Re: Railway works and all works necessary to eliminate and, where necessary, upgrade seven numbered level crossings and carry out all associated and ancillary works along a 24-kilometre section of the Dublin to Cork Railway Line.
Fantstown, Thomastown, Ballyhay, Newtown, Ballycoskery (Ballyhea Village), Shinanagh and Buttevant, Co. Cork and Co. Limerick.

Dublin to Cork Railway line (Elimination and upgrade of level crossings between Limerick Junction and Mallow) order 2021

I am writing to make you aware that I strongly object to the proposed new access road immediately east of the road over rail bridge to the north of XC211 for the following reasons:

Project: CORK LINE LEVEL CROSSINGS	
Component: RAILWAY ORDER SCHEDULE DRAWING	
Title: PROPOSED SITE PLAN - XC211 NEWTOWN	
Design: FMD	File Name: -
Drawn: JR	Original scales: PLAN 1:500 : A1
Checked: FMD	Date: SEP '20
Drawing No.: 32111000-JAC-LUH-XC211-DR-CH-0004ii

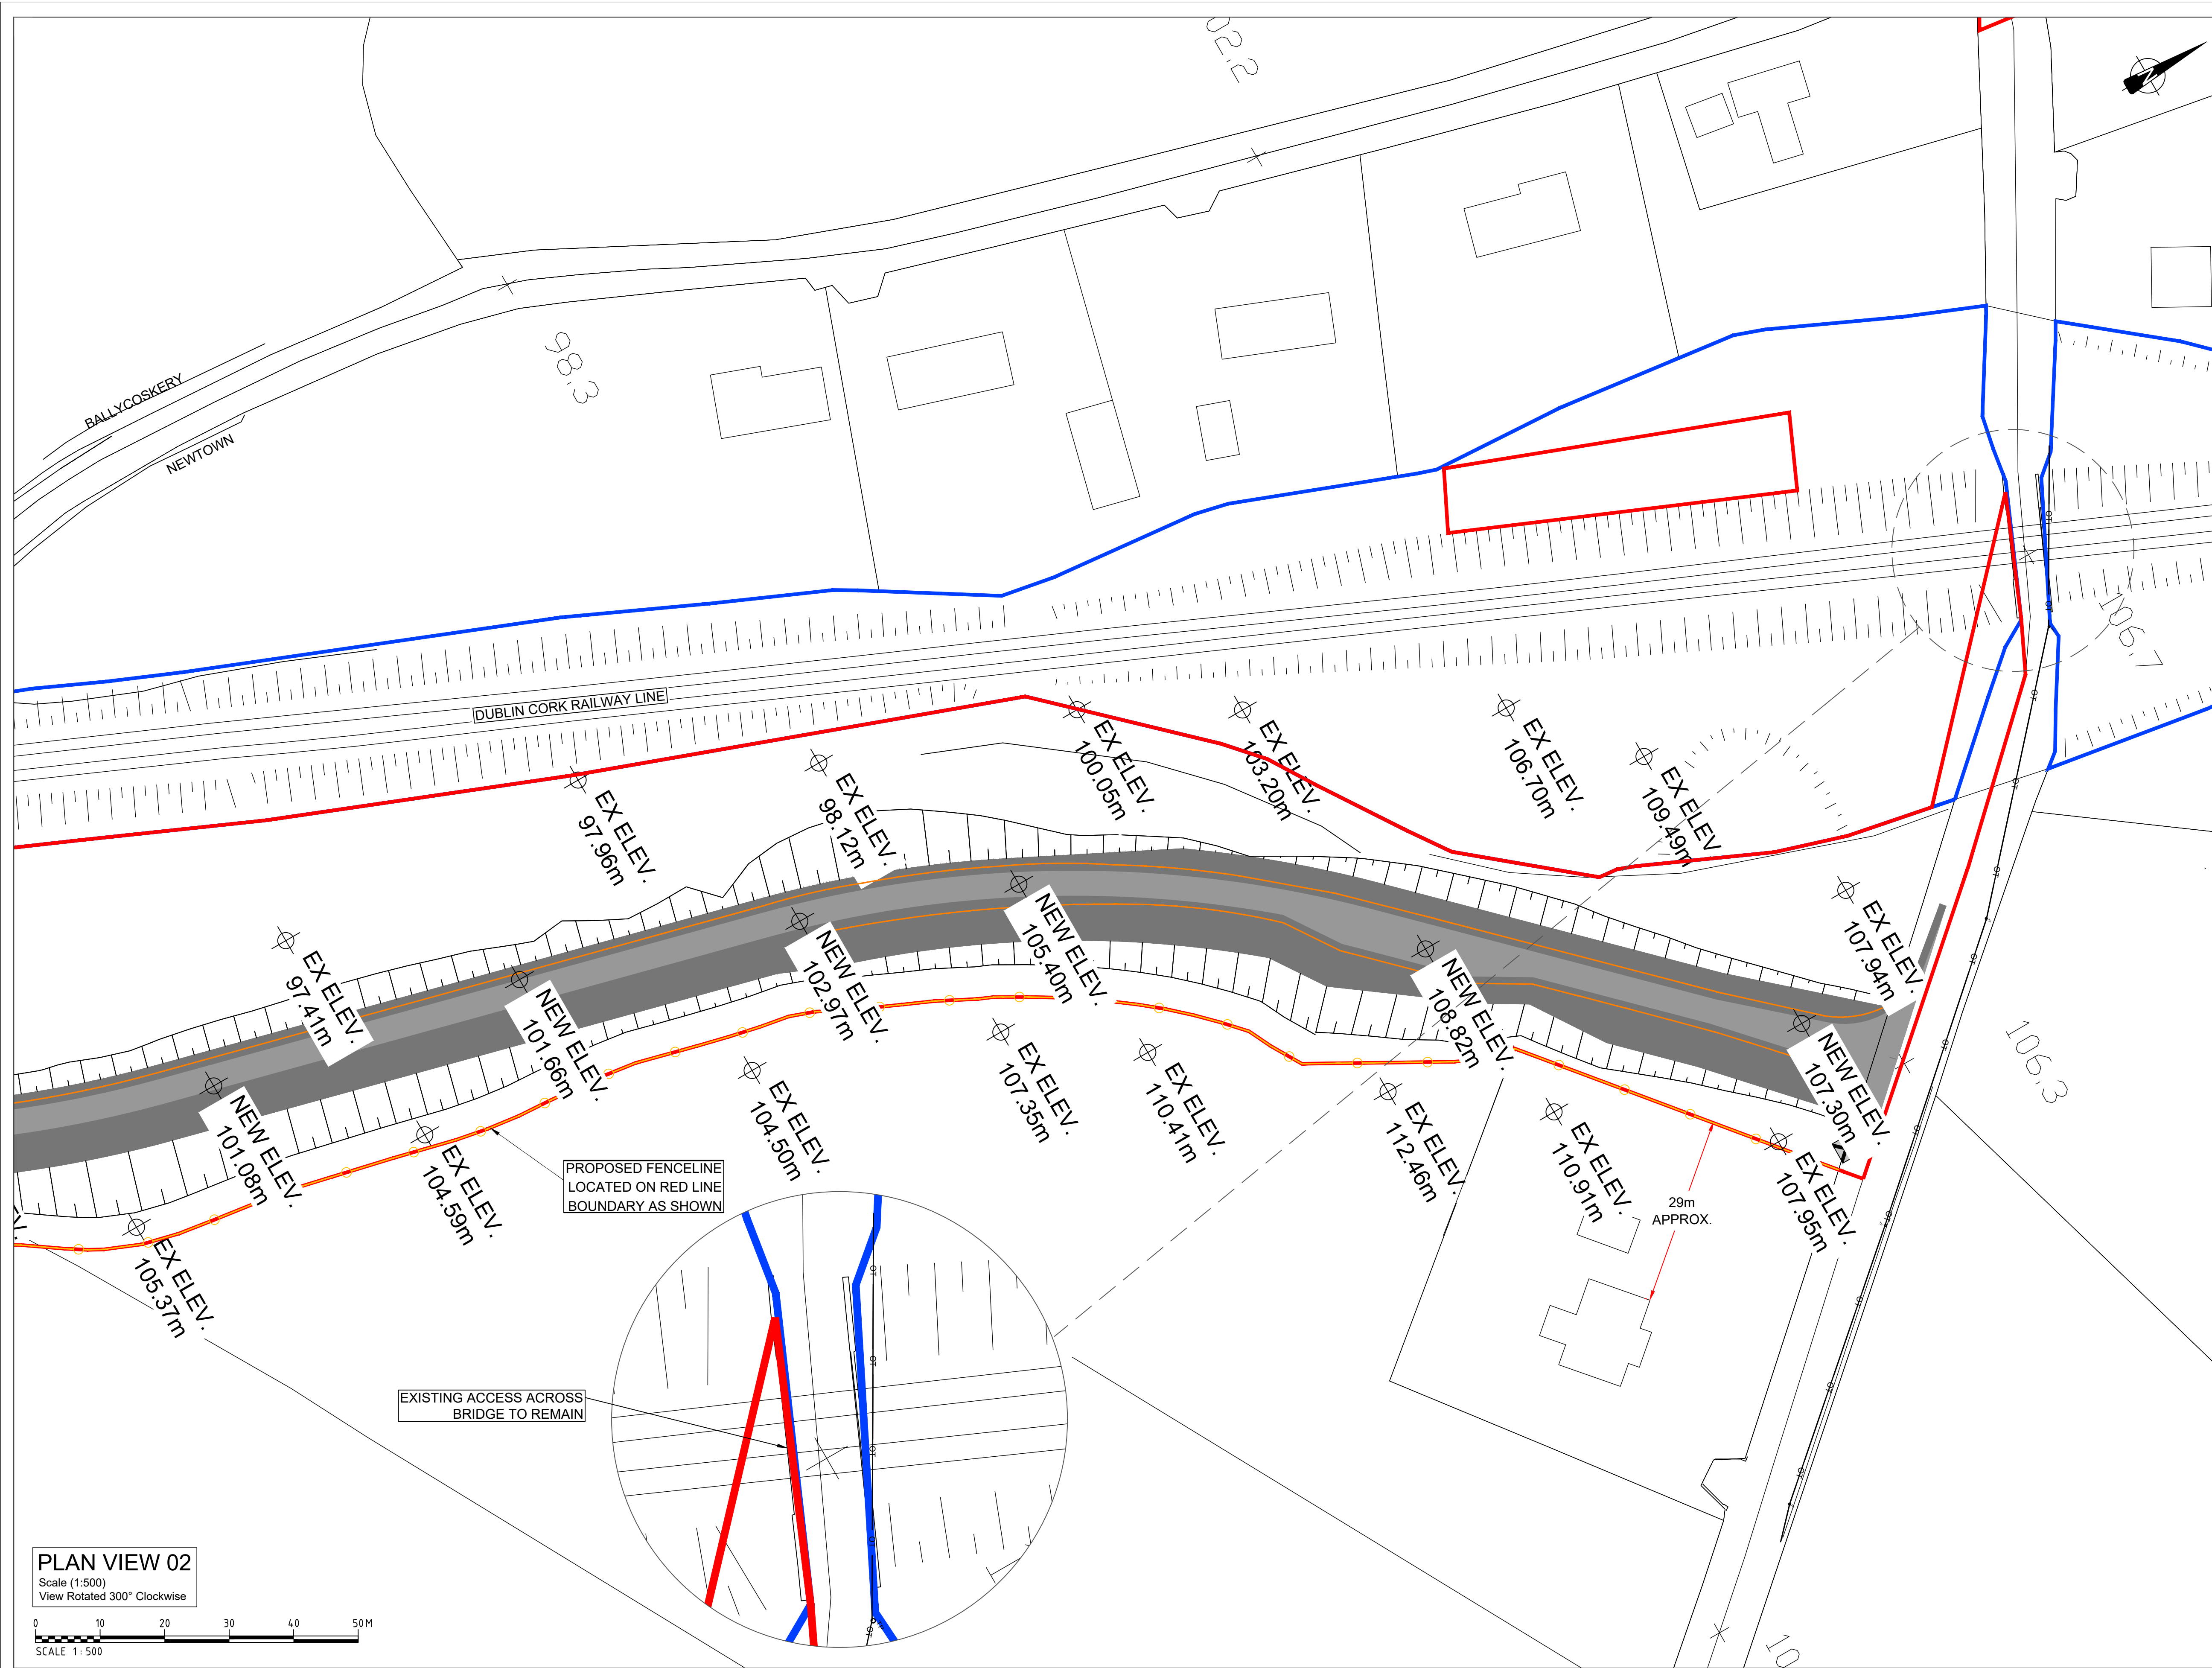
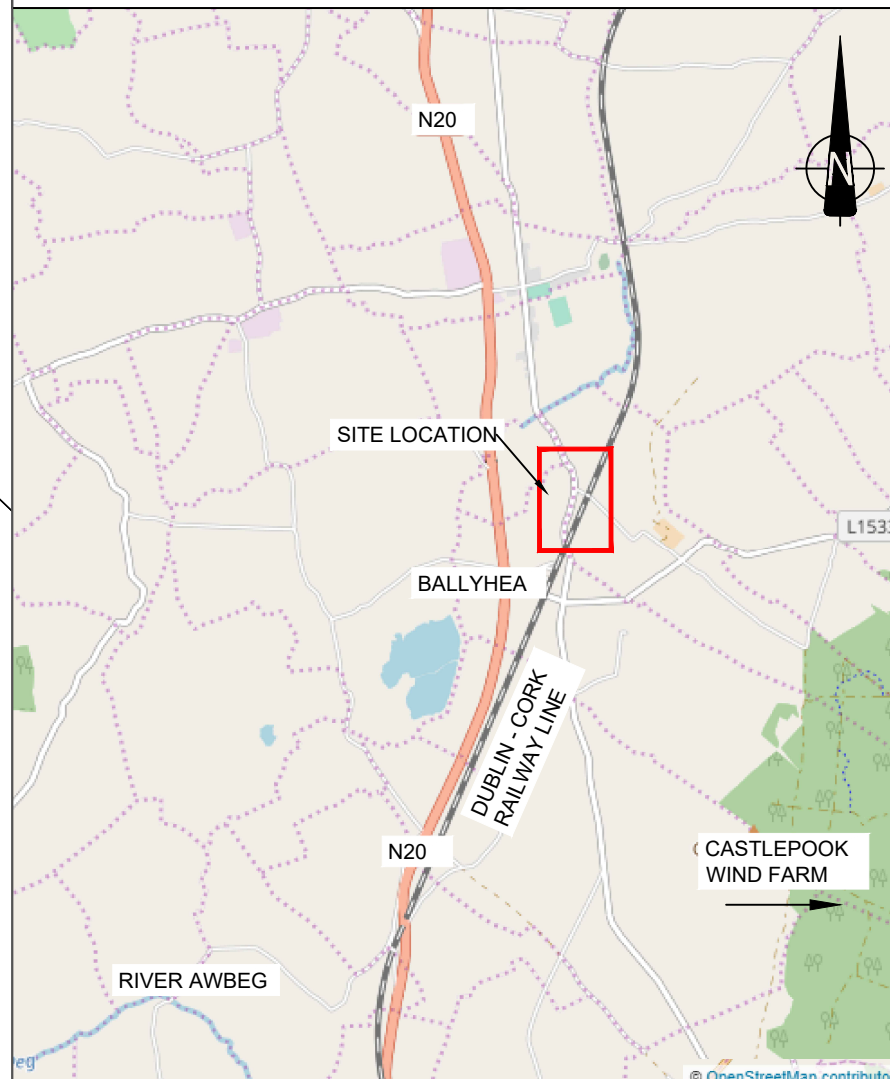
- 1) The close proximity of the boundary line to my house as shown in plan 4A. This raises major concerns for me and my family. As you can see from the drawing part of the boundary line cuts into my property which is completely unacceptable and grossly unfair as this would affect our privacy greatly, devalue our property and will make our home less secure. It is also apparent that this is the only private dwelling that is impacted out of all the seven proposed projects by CIE.
